# ENG-PUDSP21010-R2-TIS.pdf Markup Summary

See comment letters also (PCD and on-call consultant)

Figure 10a

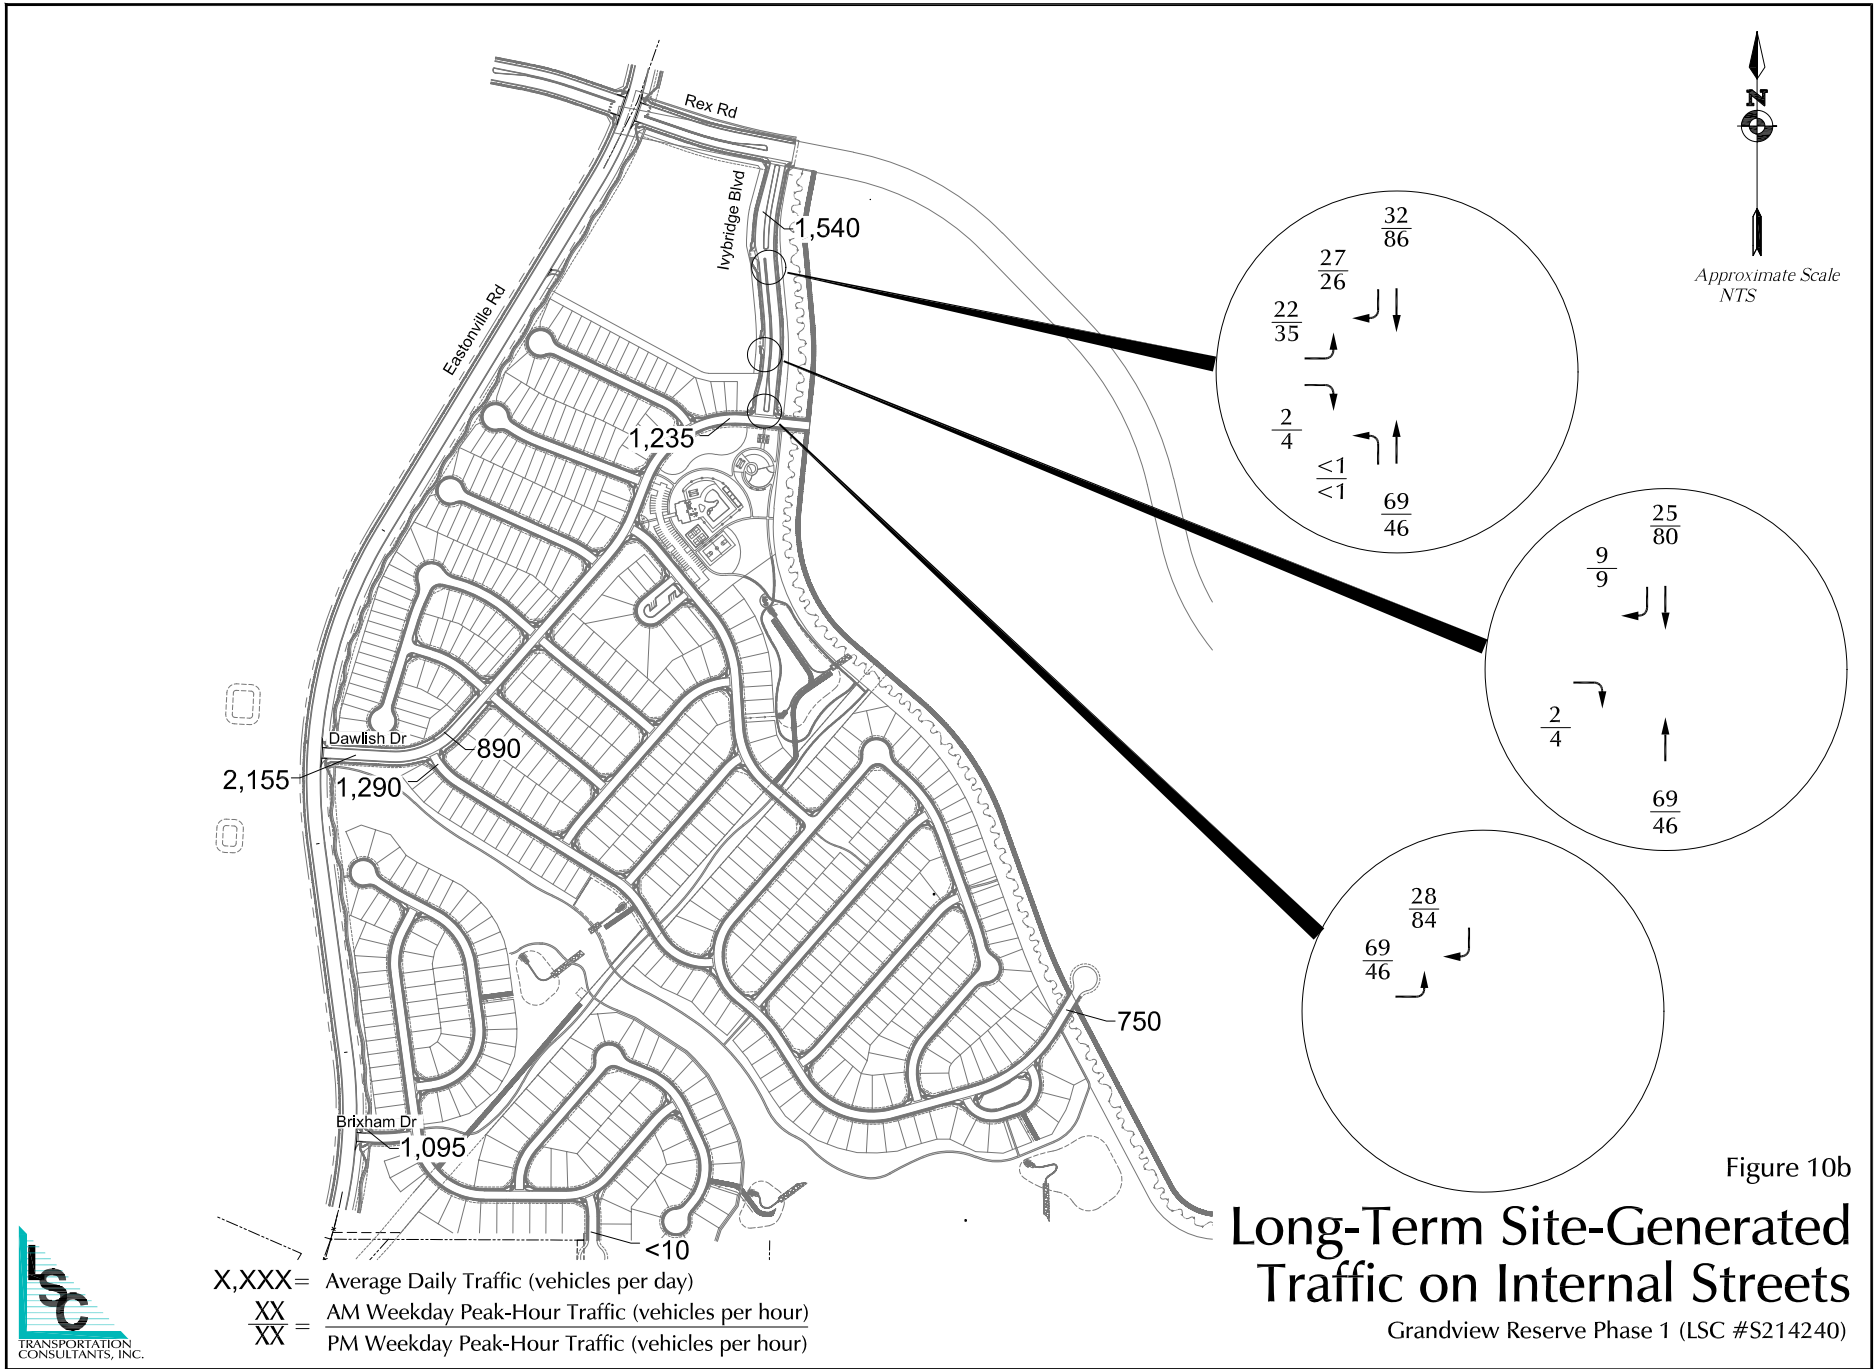
vements.  
1 in **Figure 10a** and  
ial (ECM), a westbr  
Road. This lane sh

Figure 10a

should be 155 feet  
in **Figure 10a** and  
in lane will be reqt  
n (Road "V"). Base

correct the highlighted text
